# Construction Drawings (PlansProfiles)\_v1.pdf Markup Summary

## 8-29-2022

Cursory comments

LEMON GRASS DR. (STREET L) STA: 6+00 - 7+94.08
 SCALE: H: 1"=30' V: 1"=3'

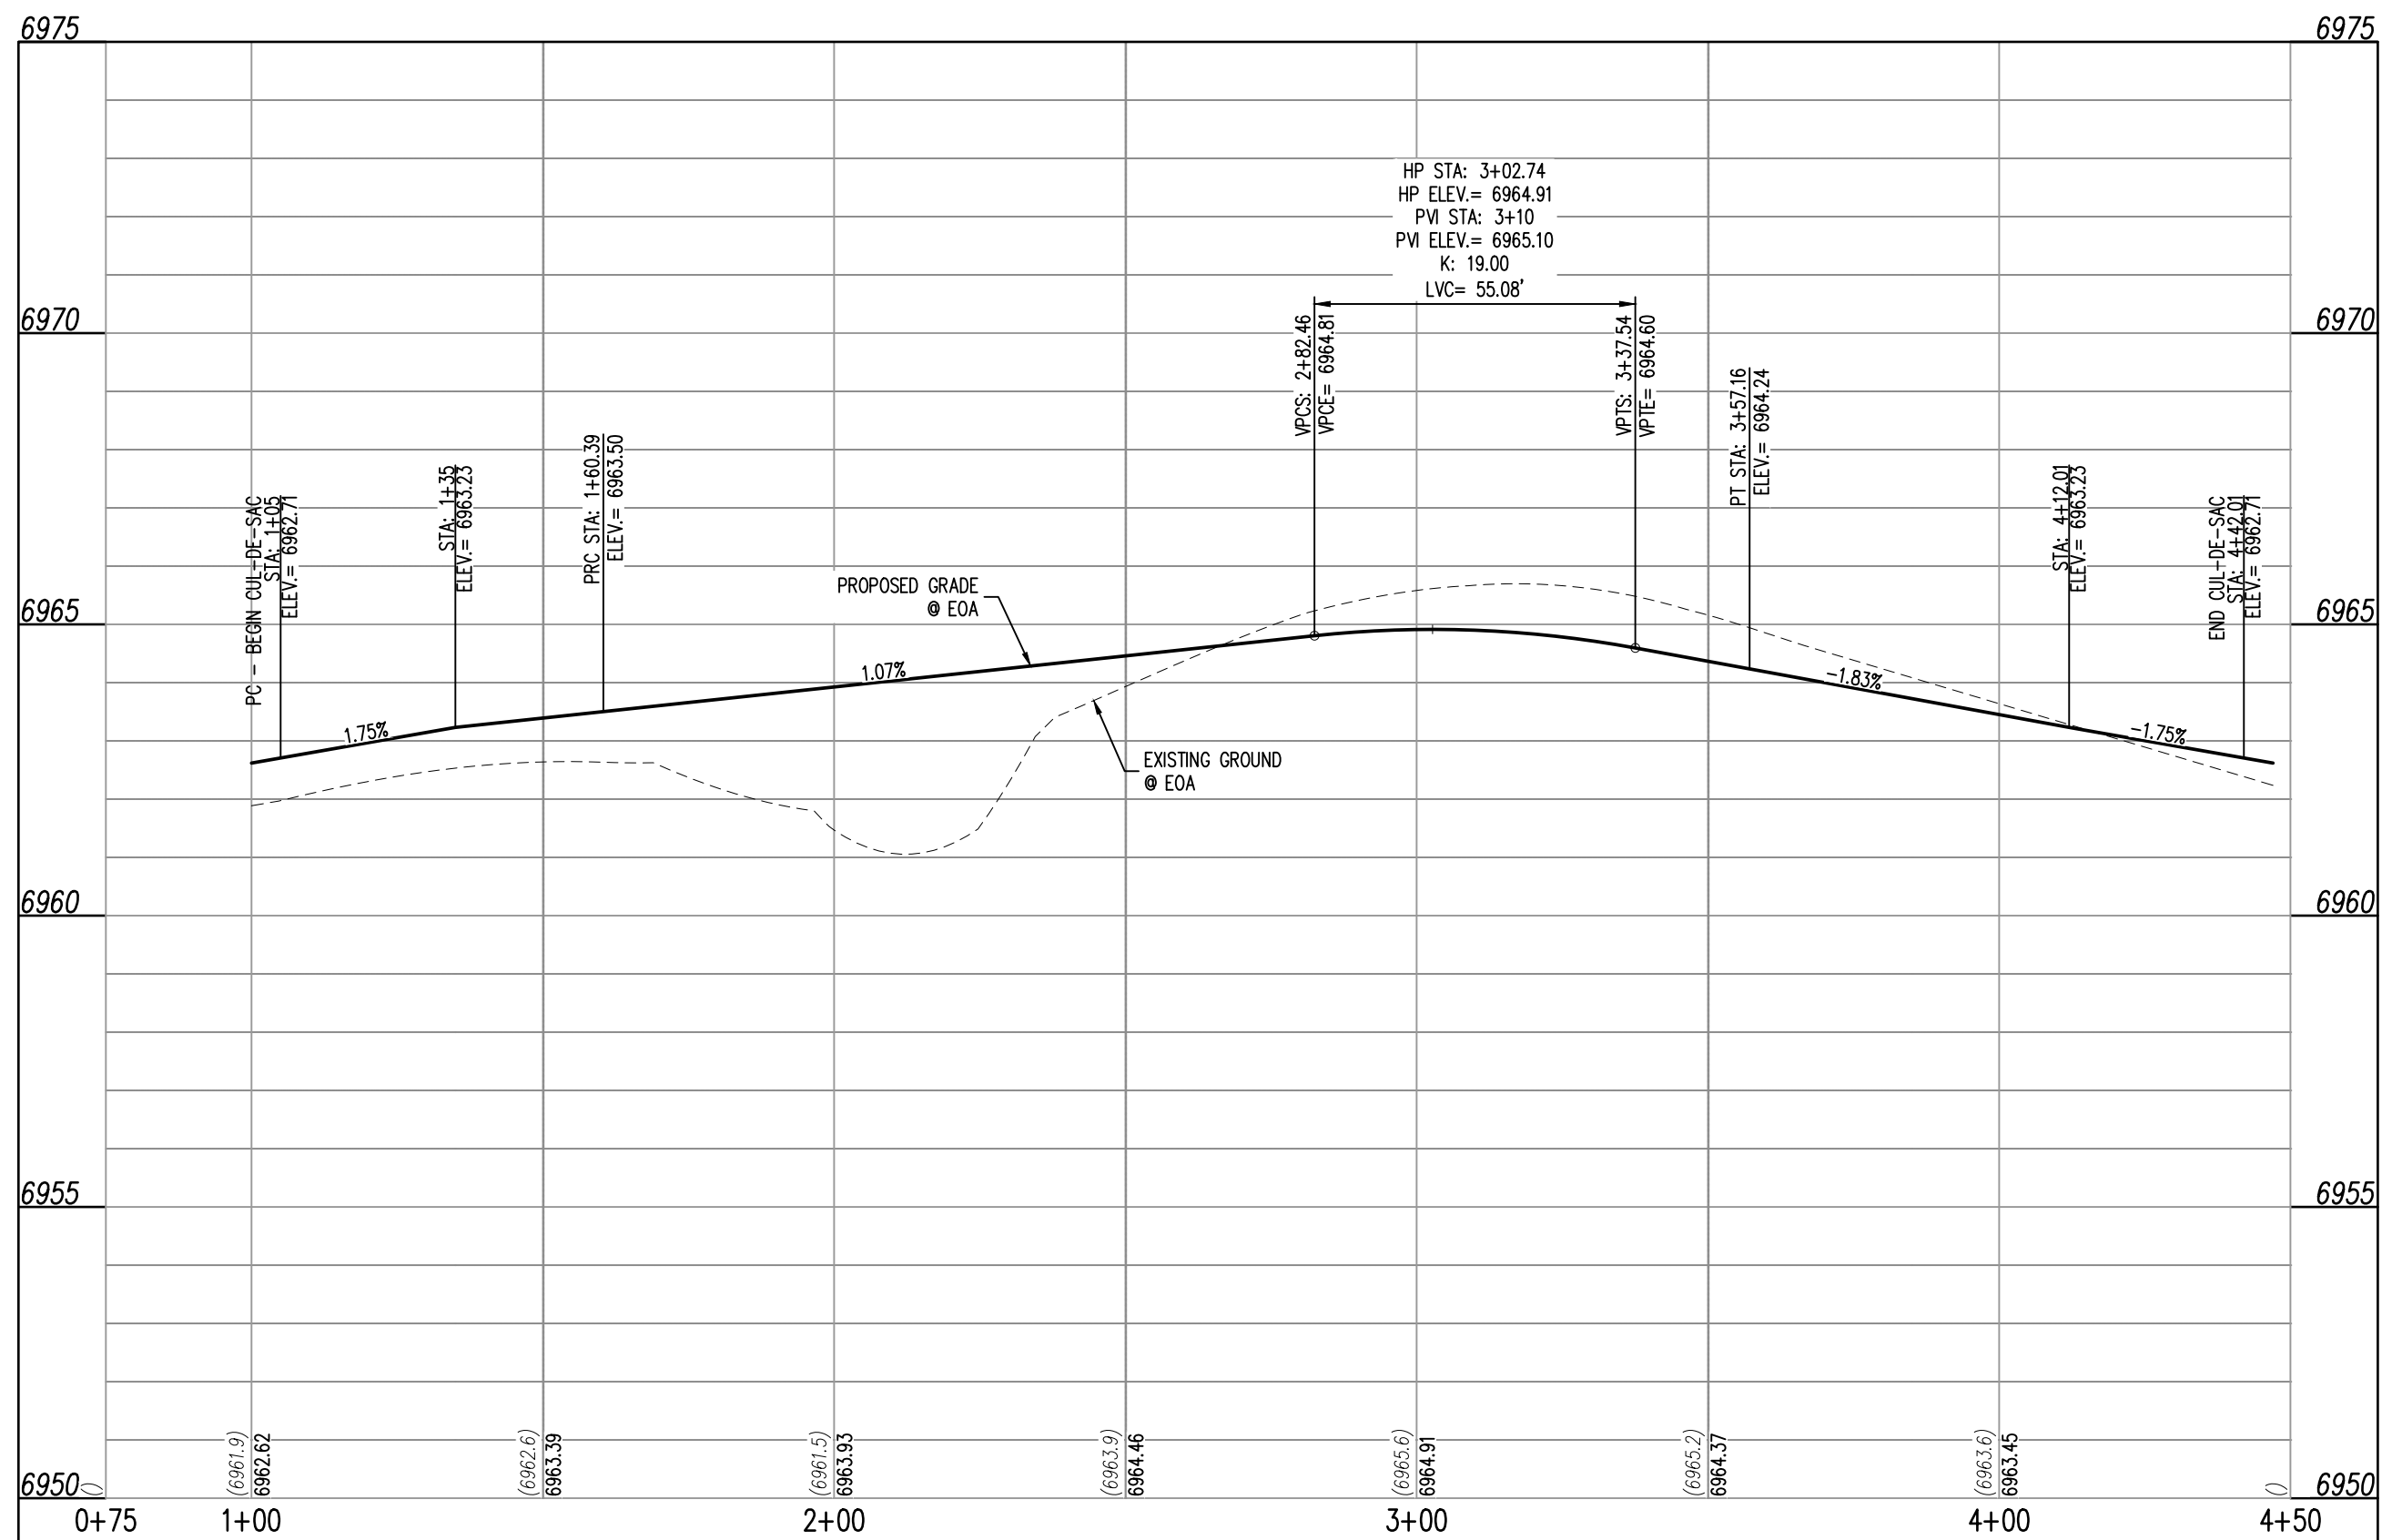
There appears to be a 3% grade break here - revise tangent to VC

Reduce grade break to <1% and space away from the vertical curve or remove and adjust the vertical curve

**Subject:** Callout  
**Page Label:** [5] 5 LEMON GRASS RD IMPROVEMENT PLAN Provide vertical curves or reduce the grade break to <1%  
**Author:** dsdrice  
**Date:** 8/19/2022 2:03:16 PM  
**Status:**  
**Color:** ■  
**Layer:**  
**Space:**

**Subject:** Callout  
**Page Label:** [5] 5 LEMON GRASS RD IMPROVEMENT PLAN Does not meet minimum K values  
**Author:** dsdrice  
**Date:** 8/19/2022 2:05:14 PM  
**Status:**  
**Color:** ■  
**Layer:**  
**Space:**

**Subject:** Callout  
**Page Label:** [5] 5 LEMON GRASS RD IMPROVEMENT PLAN Provide sight visibility triangles  
**Author:** dsdrice  
**Date:** 8/19/2022 2:46:29 PM  
**Status:**  
**Color:** ■  
**Layer:**  
**Space:**

**Subject:** Callout  
**Page Label:** [5] 5 LEMON GRASS RD IMPROVEMENT PLAN Label as centerline-centerline intersections  
**Author:** dsdrice  
**Date:** 8/19/2022 2:48:41 PM  
**Status:**  
**Color:** ■  
**Layer:**  
**Space:**

ROAD IMPROVEMENT
 PLANS

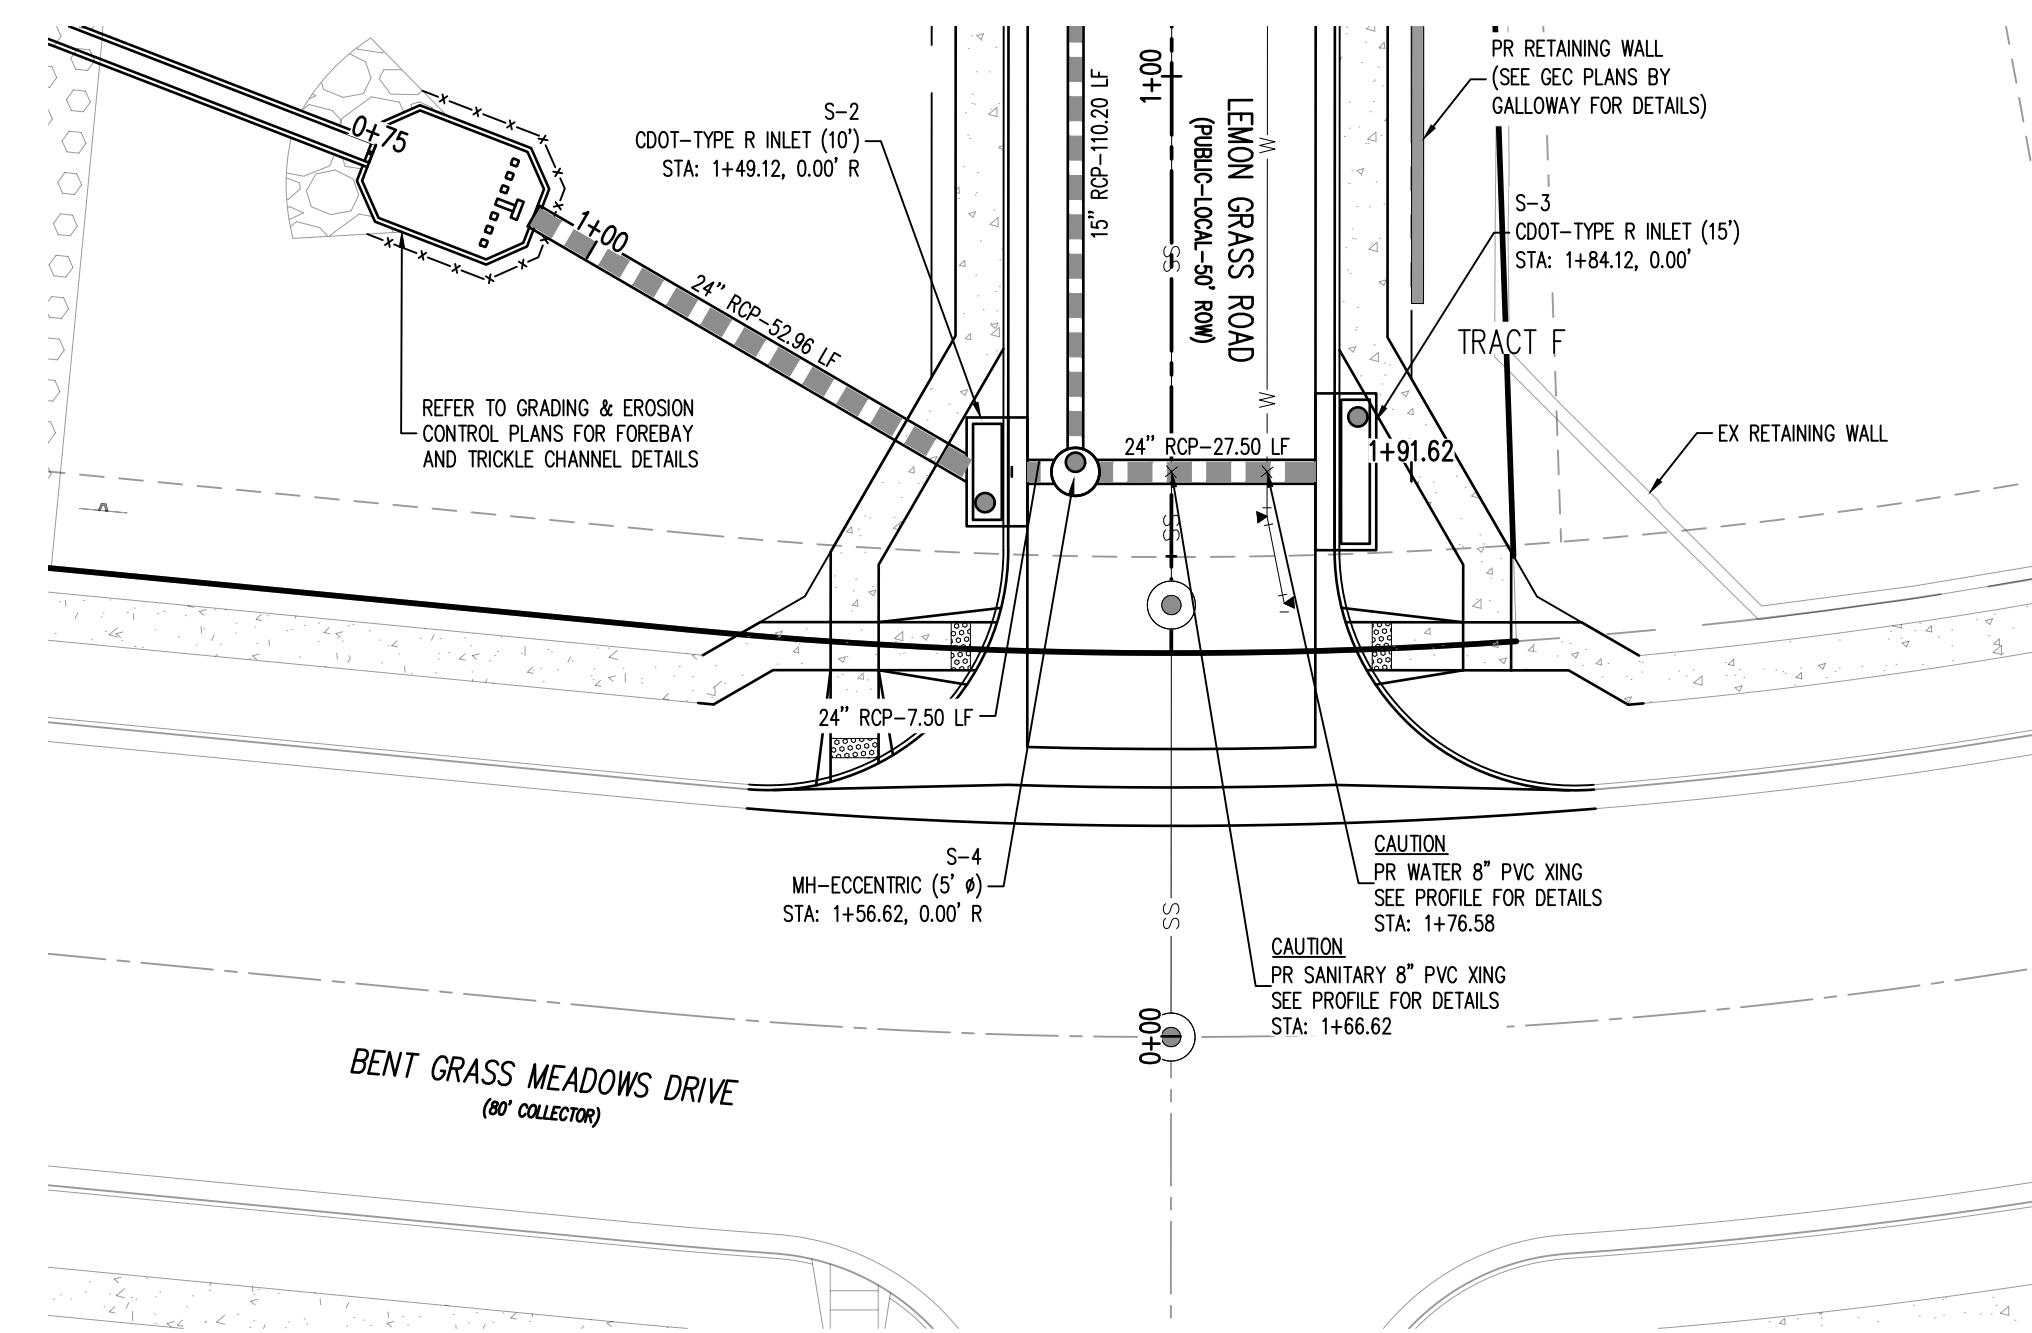
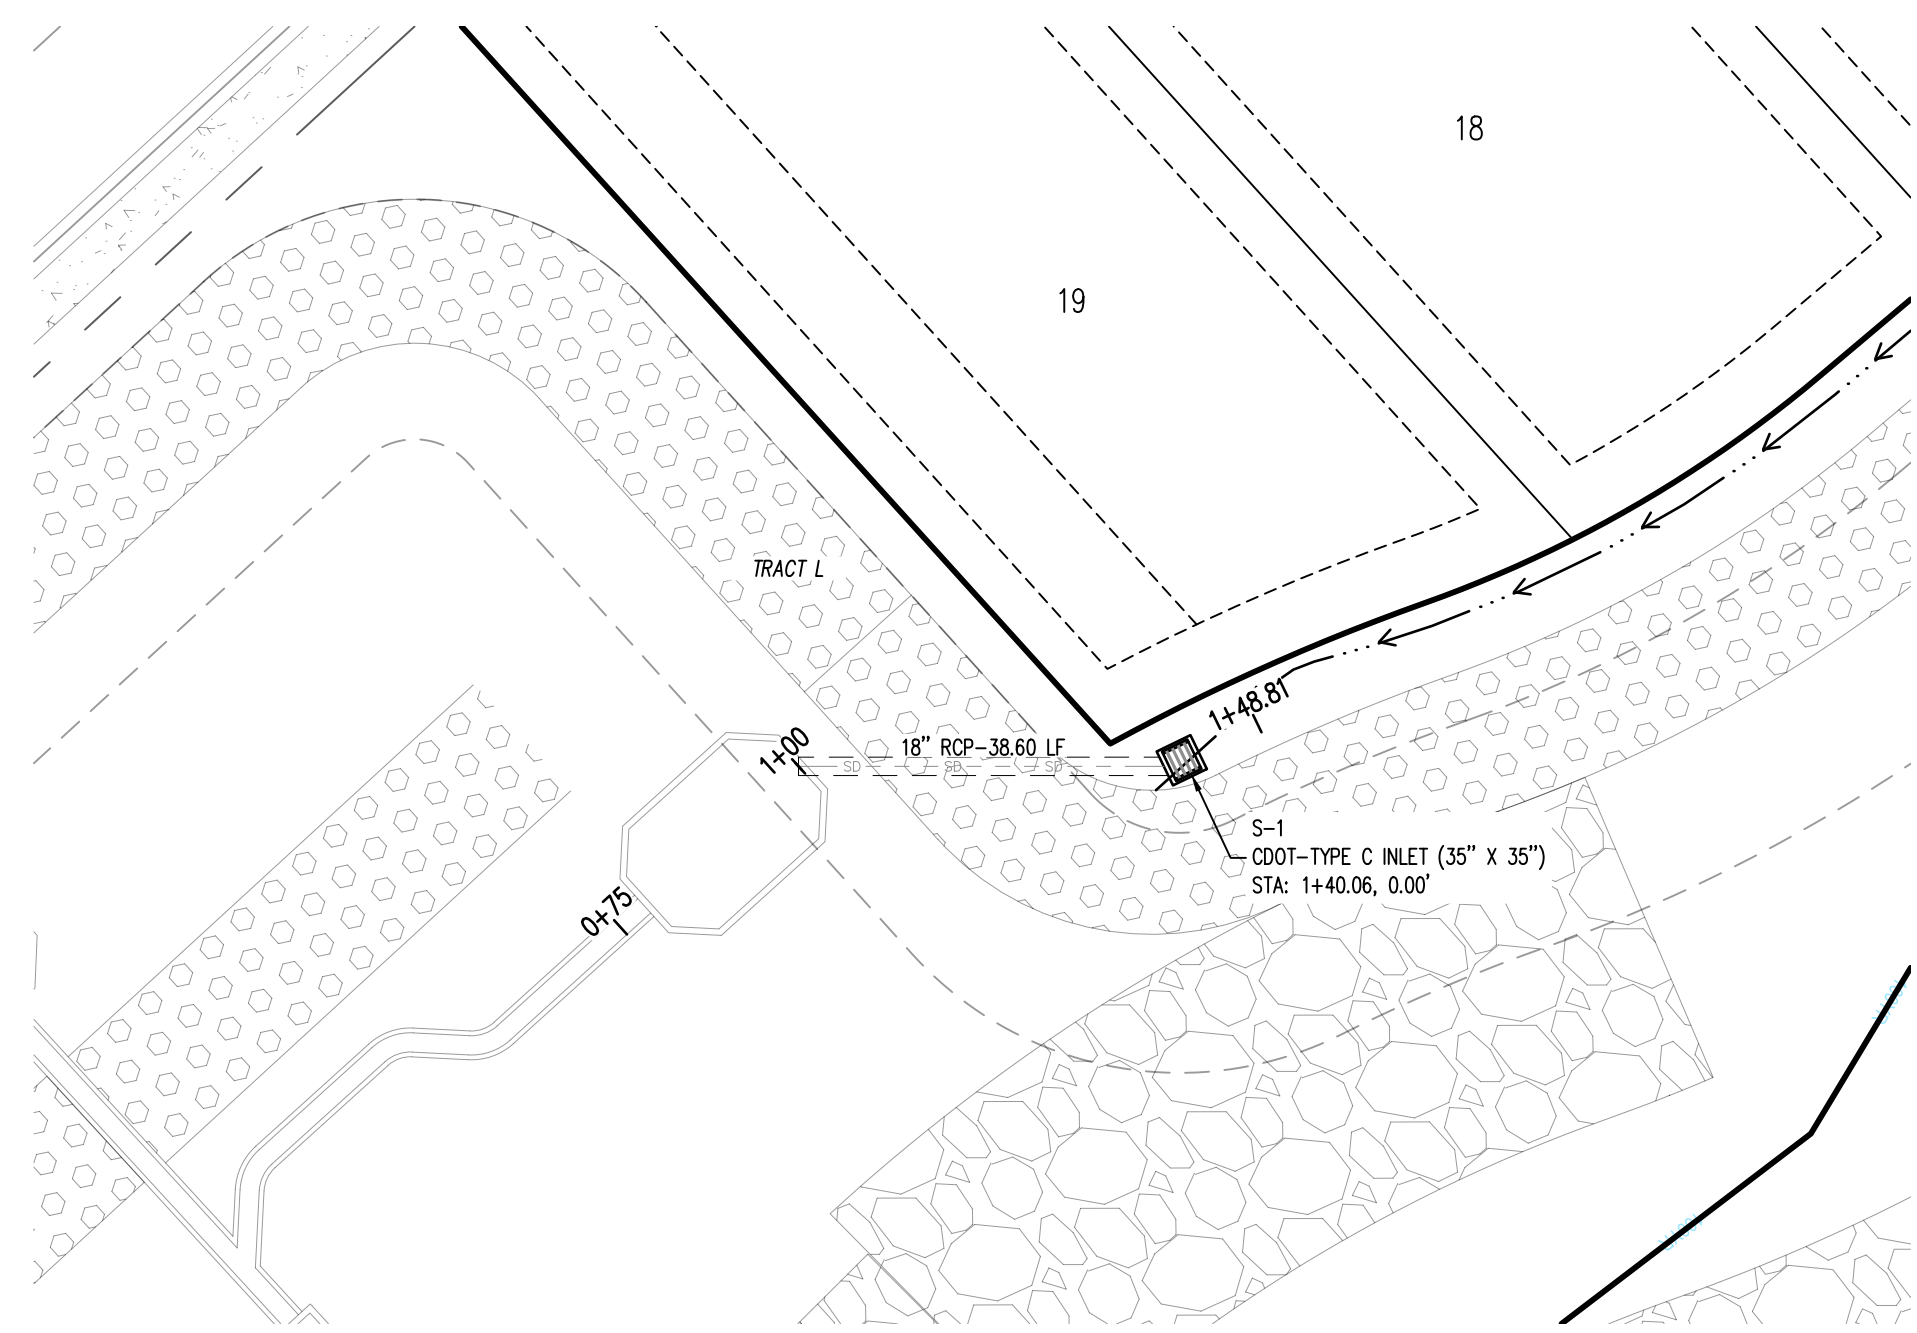
**Subject:** Callout  
**Page Label:** [7] 7 ROAD IMPROVEMENT PLANS Call out crosspans and per SD\_2-26  
**Author:** dsdrice  
**Date:** 8/19/2022 2:14:36 PM  
**Status:**  
**Color:** ■  
**Layer:**  
**Space:**

**Subject:** Callout  
**Page Label:** [7] 7 ROAD IMPROVEMENT PLANS Show and label the existing 3% grade; revise design as appropriate  
**Author:** dsdrice  
**Date:** 8/19/2022 2:13:19 PM  
**Status:**  
**Color:** ■  
**Layer:**  
**Space:**

**Subject:** Callout  
**Page Label:** [7] 7 ROAD IMPROVEMENT PLANS Show and label the existing 3% grade; revise design as appropriate  
**Author:** dsdrice  
**Date:** 8/19/2022 2:13:09 PM  
**Status:**  
**Color:** ■  
**Layer:**  
**Space:**
